Town & Country Planning Act 1990 (as amended)
Town and Country Planning (Development Management Procedure) (England) Order 2015
Approval of details reserved by condition imposed under ref APP/C3810/W/16/3155330 (AL/8/16/OUT)
relating to Condition Nos 11 - visibility splay, 12 - fire hydrant, 13 - foul drainage, 14 - surface water
drainage and 18 - external lighting
Land To South Of Barnside Hook Lane Aldingbourne PO20 3TE

Condition Number 11

Arun District Council have decided to **APPROVE details reserved by this condition**

P4	11.09.19	AMENDED TO SUIT WSSC COMMENTS.	PJM
P3	15.07.19	NOTE TO TELEPHONE POLE ADDED.	JMB
P2	01.07.19	EXTENT OF WORKS AMENDED.	JMB
P1	14.06.19	PRELIMINARY ISSUE FOR COMMENT	JMB
Revision	Date	Description	By

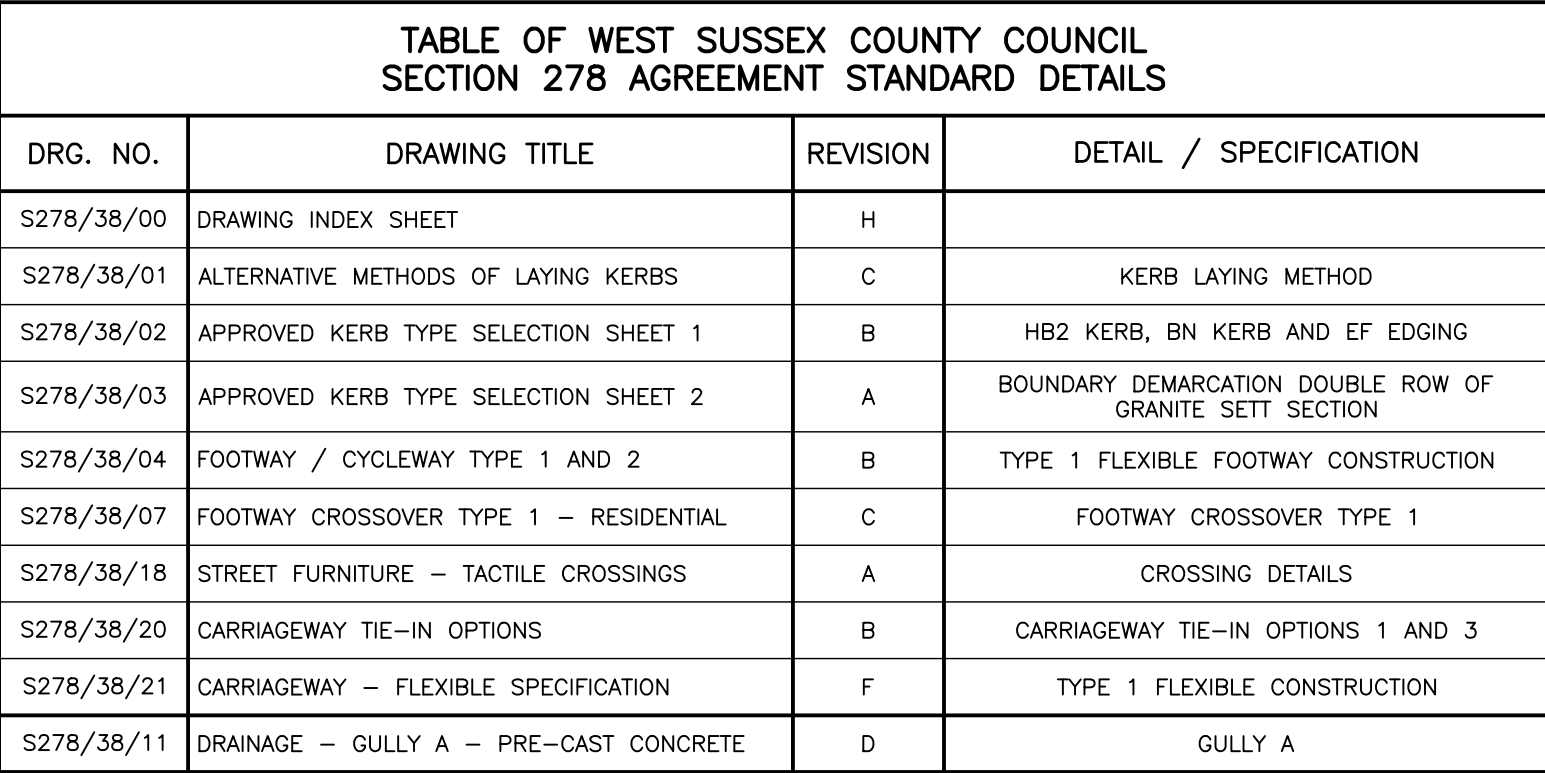
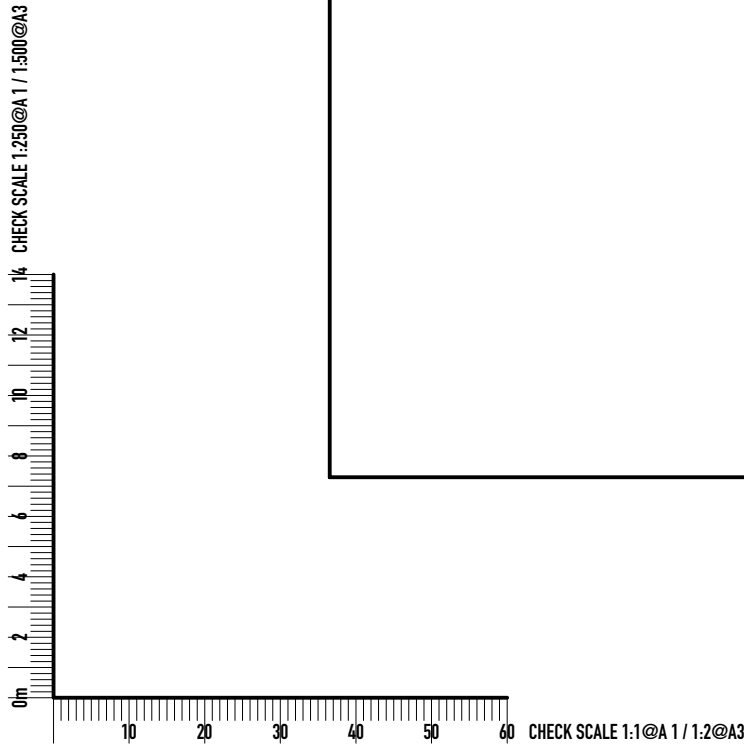
The details submitted on Drawing AAL 156-520 P4 demonstrate that the required visibility splays can be achieved. WSCC Highways therefore consider that this condition may be discharged.

The condition is therefore fully discharged insofar as the submission of details relates and on the understanding that the visibility splays will be implemented in accordance with the submitted drawings and permanently retained thereafter.
